Springwell Solar Farm

ES Volume 2: Figures

Chapter 3: Proposed Development Description

EN010149/APP/6.2.2

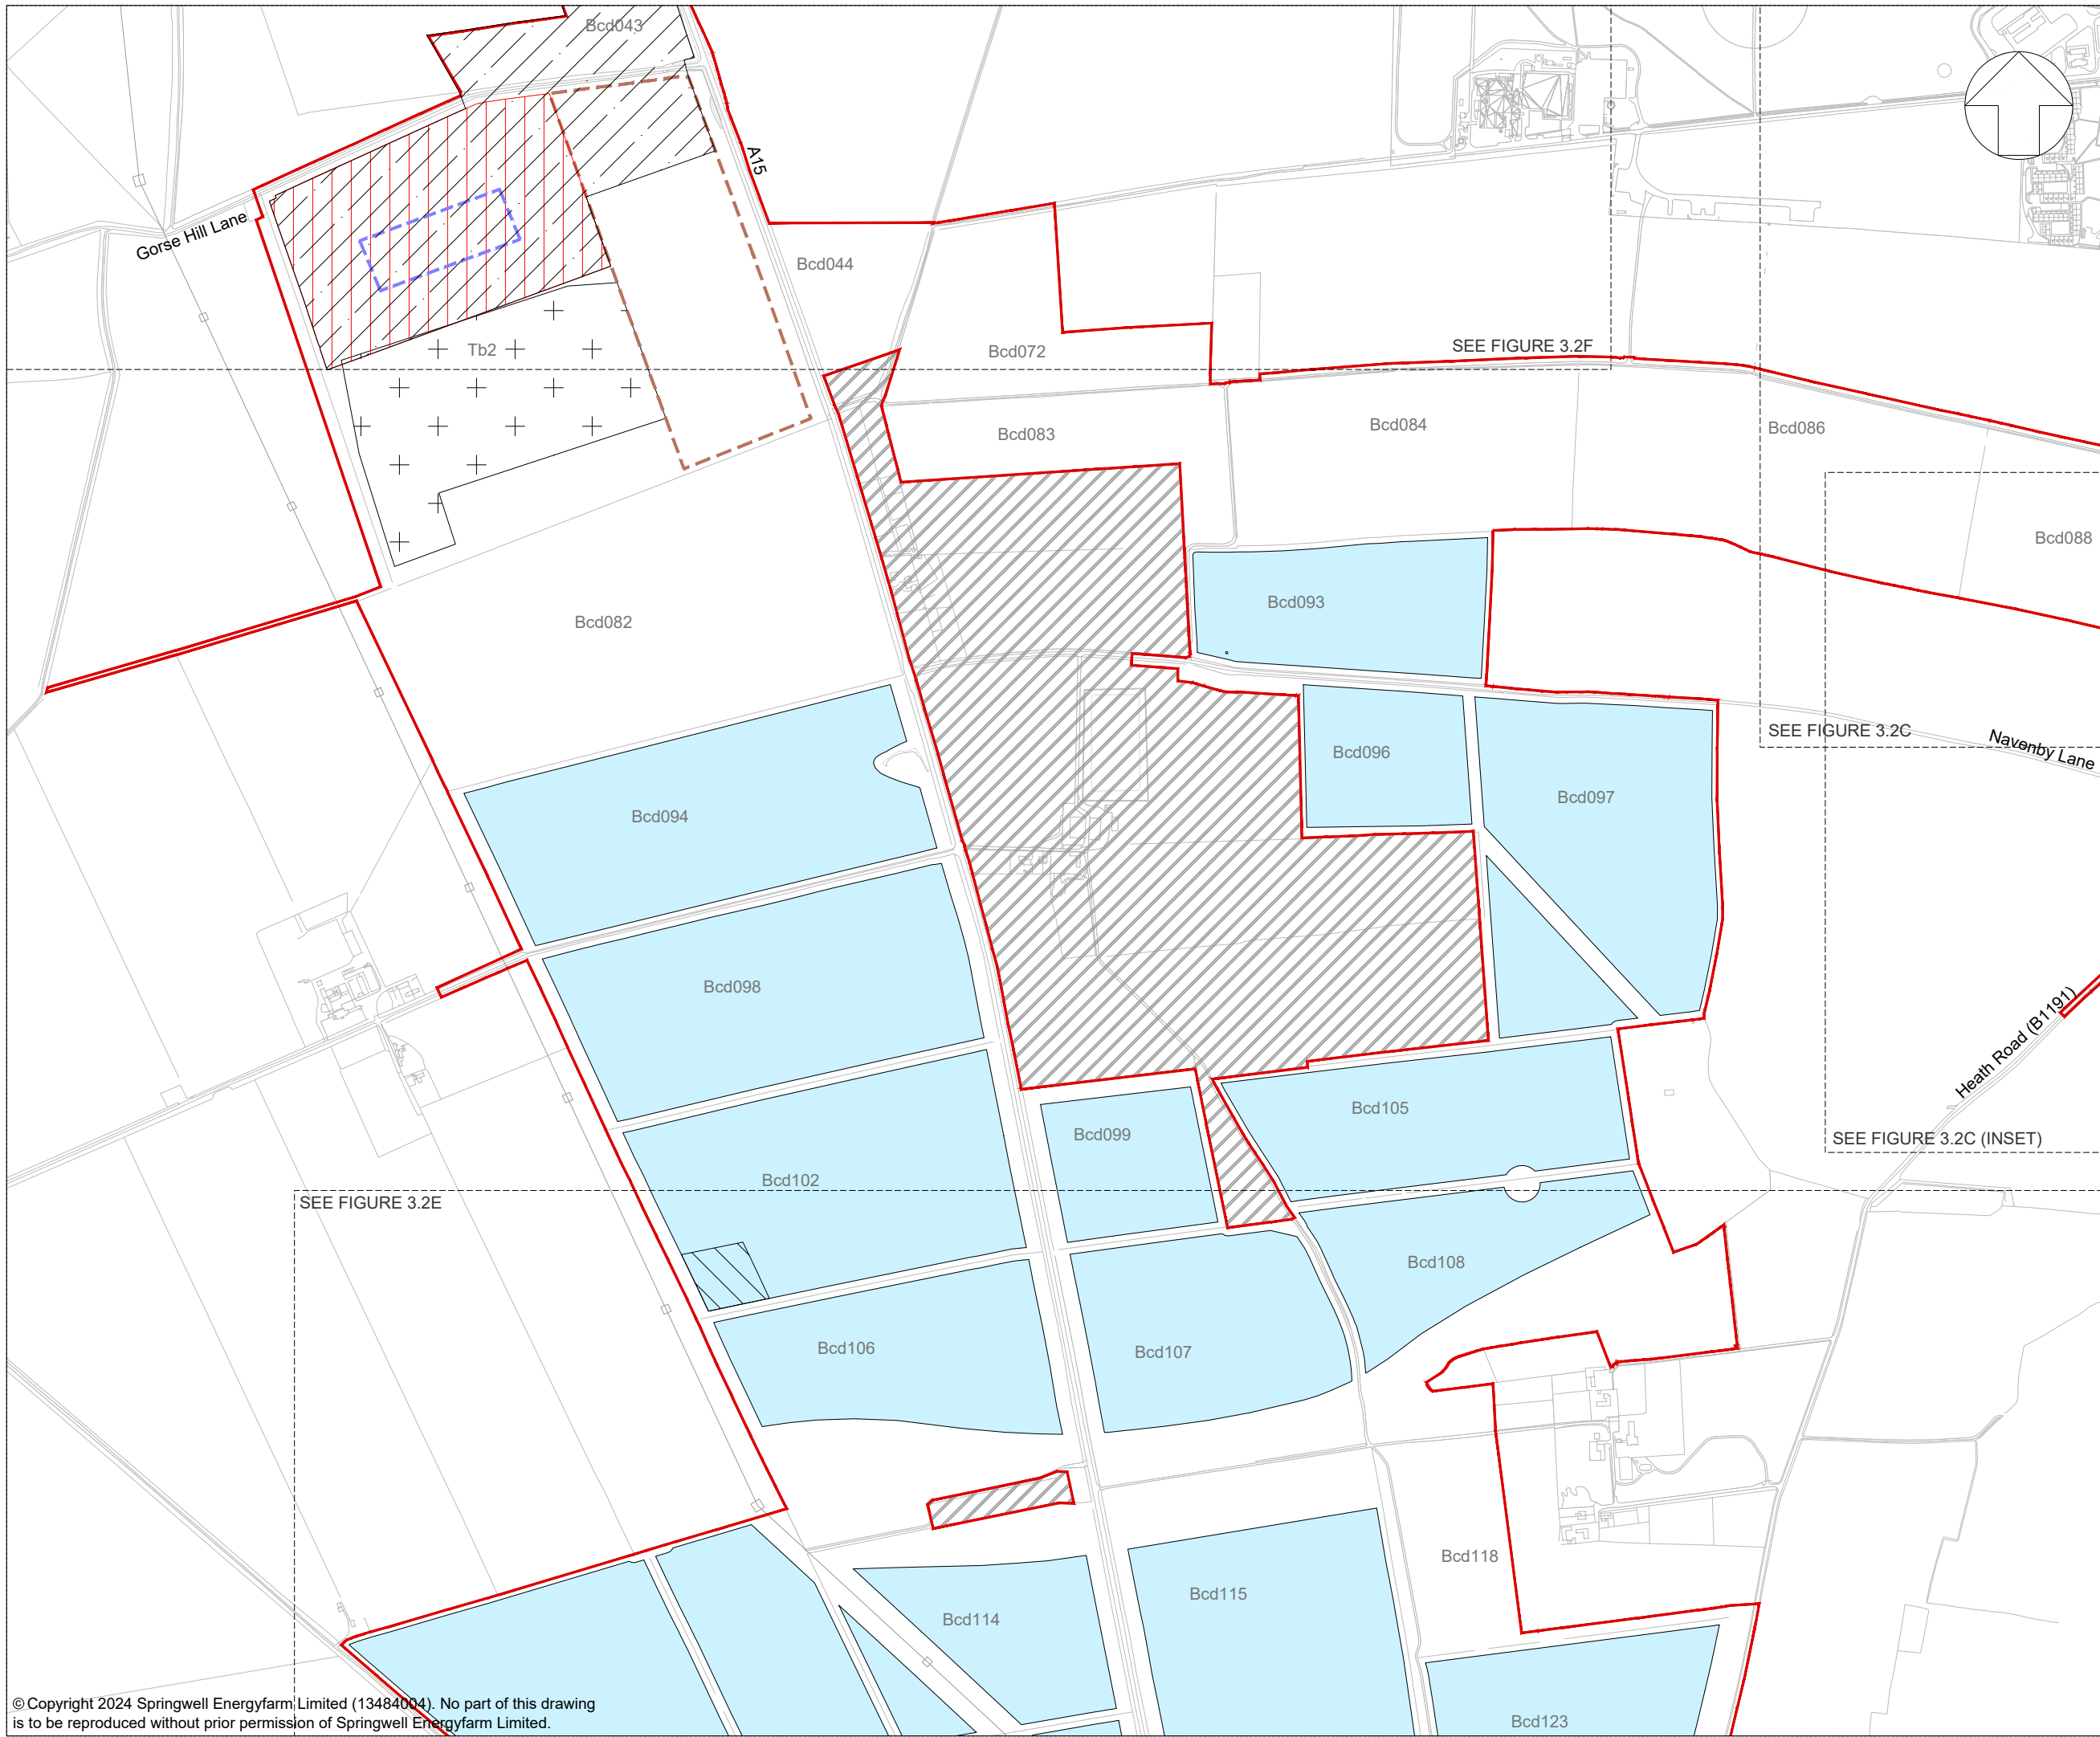
Drawing number	Revision number	Drawing title	Scale	Reason for revision
Figure 3.1	02	Zonal Masterplan	A3	Drawing correction to show shading for 'Proposed area for Solar PV Development' on plan.
Figure 3.2A-F	01	Height Parameters	A3	No change made
Figure 3.3A	02	Green Infrastructure Parameters	A3	Drawing correction to show shading for 'Grassland under Solar PV modules' on plan. Additional hedgerow removal in Bcd068 (2m) and Bcd128 (2m) to facilitate crossing point for proposed Public Right of Way. Proposed Public Right of Way extended in Bcd128. Proposed permissive path extended in Bcd139 to facilitate circular walking loop.
Figure 3.3B	02	Green Infrastructure Parameters	A3	Drawing correction to show shading for 'Grassland under Solar PV modules' on plan.
Figure 3.3C	02	Green Infrastructure Parameters	A3	Drawing correction to show shading for 'Grassland under Solar PV modules' on plan. Additional section of hedgerow removed (2m) in Bcd068 to facilitate crossing point for proposed Public Right of Way.

TITLE:
 FIGURE 3.11C
 VEGETATION REMOVAL PARAMETERS
 SRPINGWELL CENTRAL

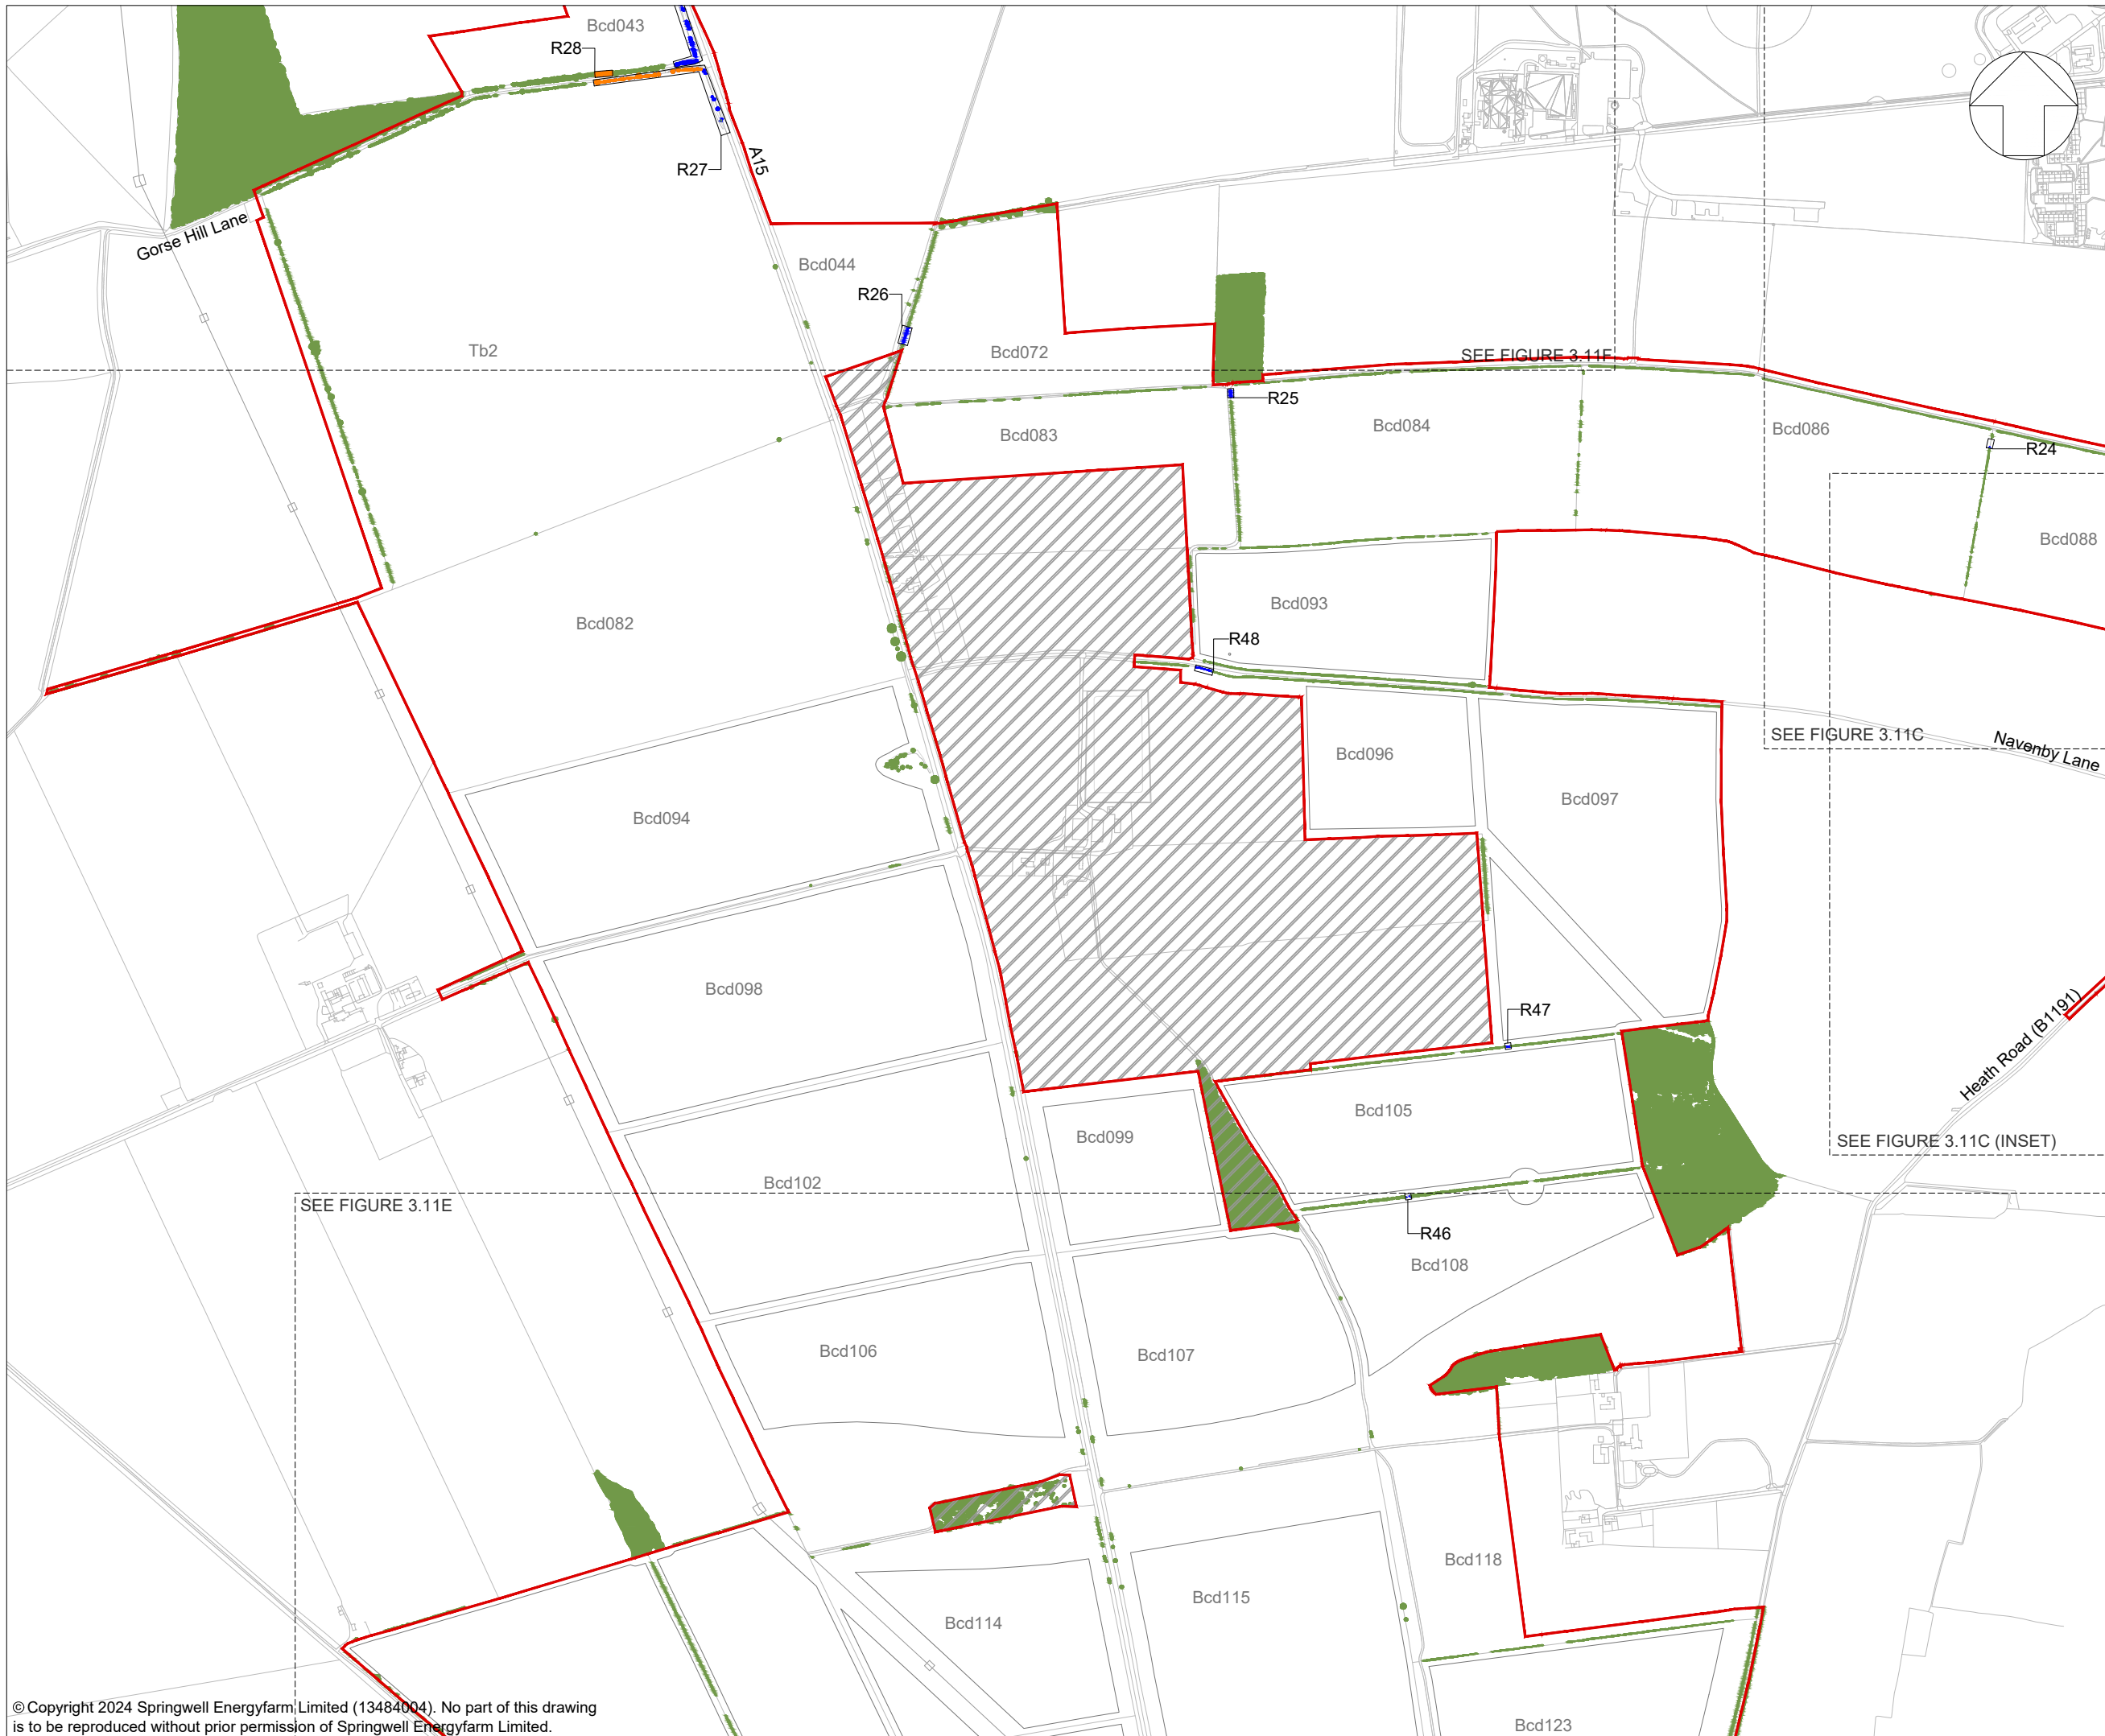
Drawing number	Revision number	Drawing title	Scale	Reason for revision
Figure 3.11B	01	Vegetation Removal Parameters	A3	No change made
Figure 3.11C	02	Vegetation Removal Parameters	A3	Area of Vegetation to be removed box added. Reference R49 (2m) in Bcd068.
Figure 3.11D	01	Vegetation Removal Parameters	A3	No change made
Figure 3.11E	02	Vegetation Removal Parameters	A3	Area of Vegetation to be removed box added. Reference R50 (2m) in Bcd128.
Figure 3.11F	01	Vegetation Removal Parameters	A3	No change made
Figure 3.12	01	Typical Security Details	A3	No change made
Figure 3.13	01	Indicative Drainage Cross Sections	A3	No change made
Figure 3.14	01	Indicative Location of Internal Access Tracks	A3	No change made
Figure 3.15	01	Indicative Watercourse and Ditch Crossing Locations	A3	No change made
